TO: Inspections Department

FROM: Philip DiPierro, Development Review Coordinator

DATE: November 16, 2009

RE: C. of O. for #132 Riverside Street, Burger King  
(Id#2008-0053) (CBL 267 A 007001)

GREENBRIAR FLAT LENS

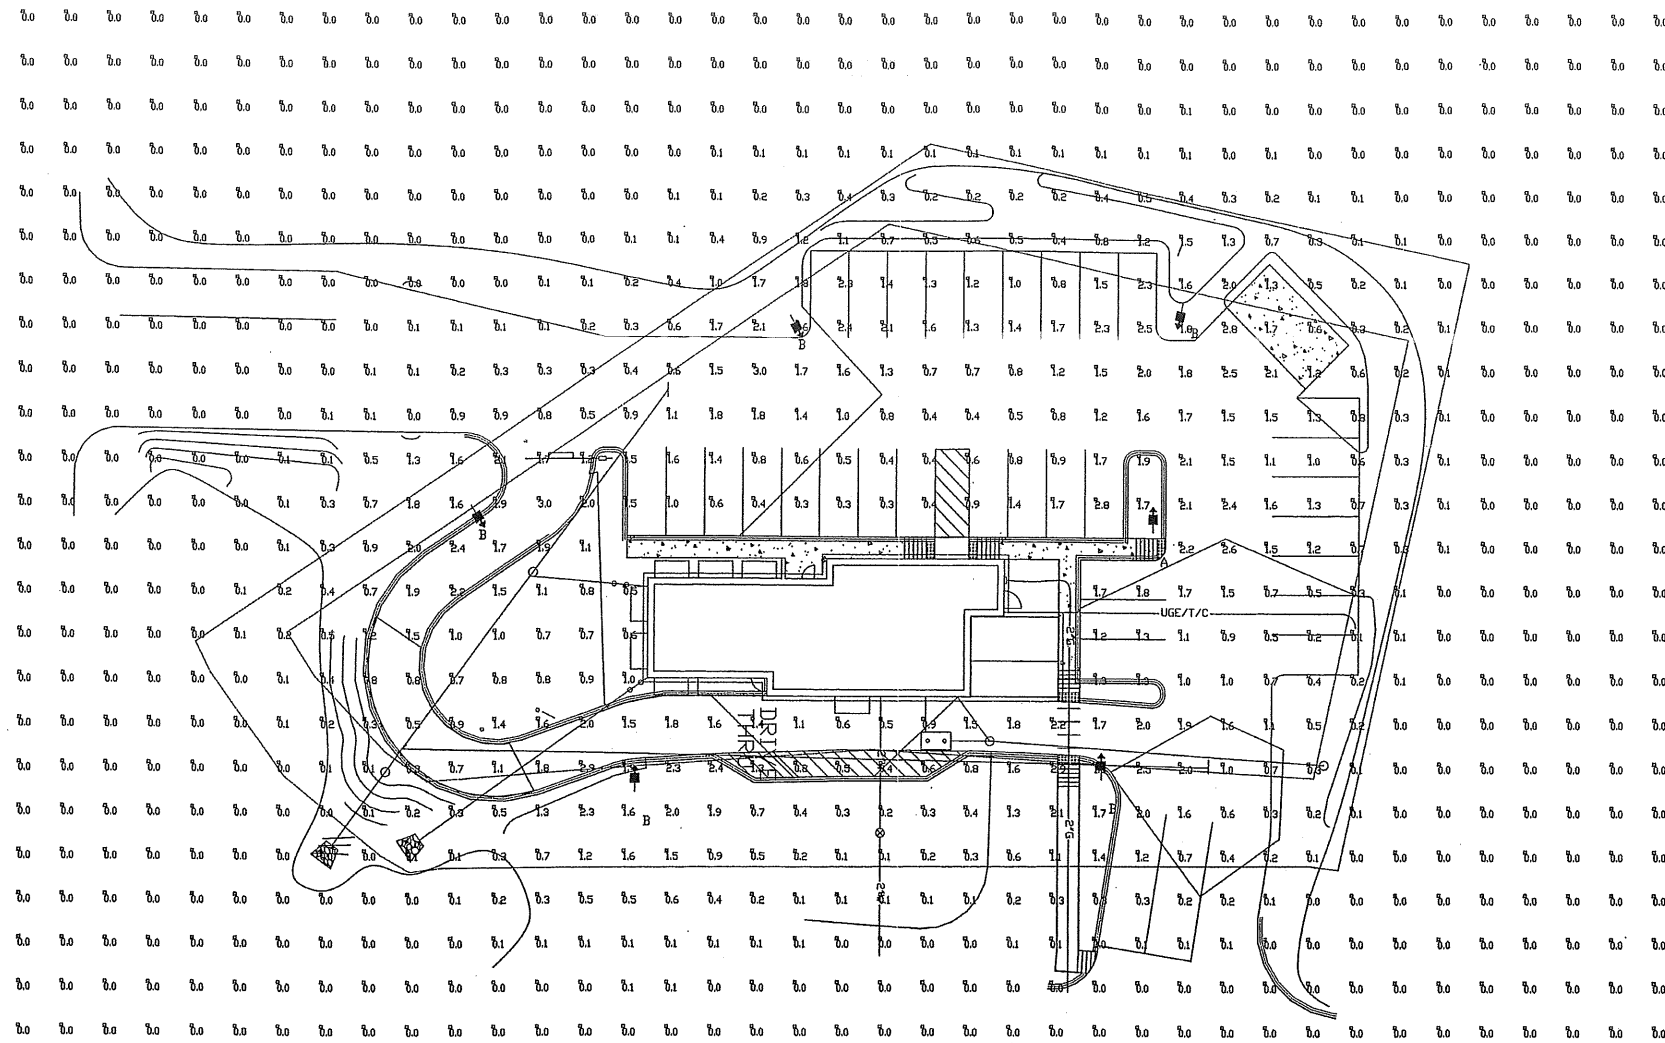
1. A revised photometrics plan shall be submitted to include an analysis of all building/canopy mounted lights. If lighting is non-compliant, measures will be taken to meet compliance.
2. The applicant shall comply with any forthcoming conditions by Maine D.O.T. and the City of Portland concerning the Riverside Street access point, as will be determined through pending review of the proposal, within a reasonable time frame.. Any and all required work must be completed prior to the issuance of the permanent Certificate of Occupancy.
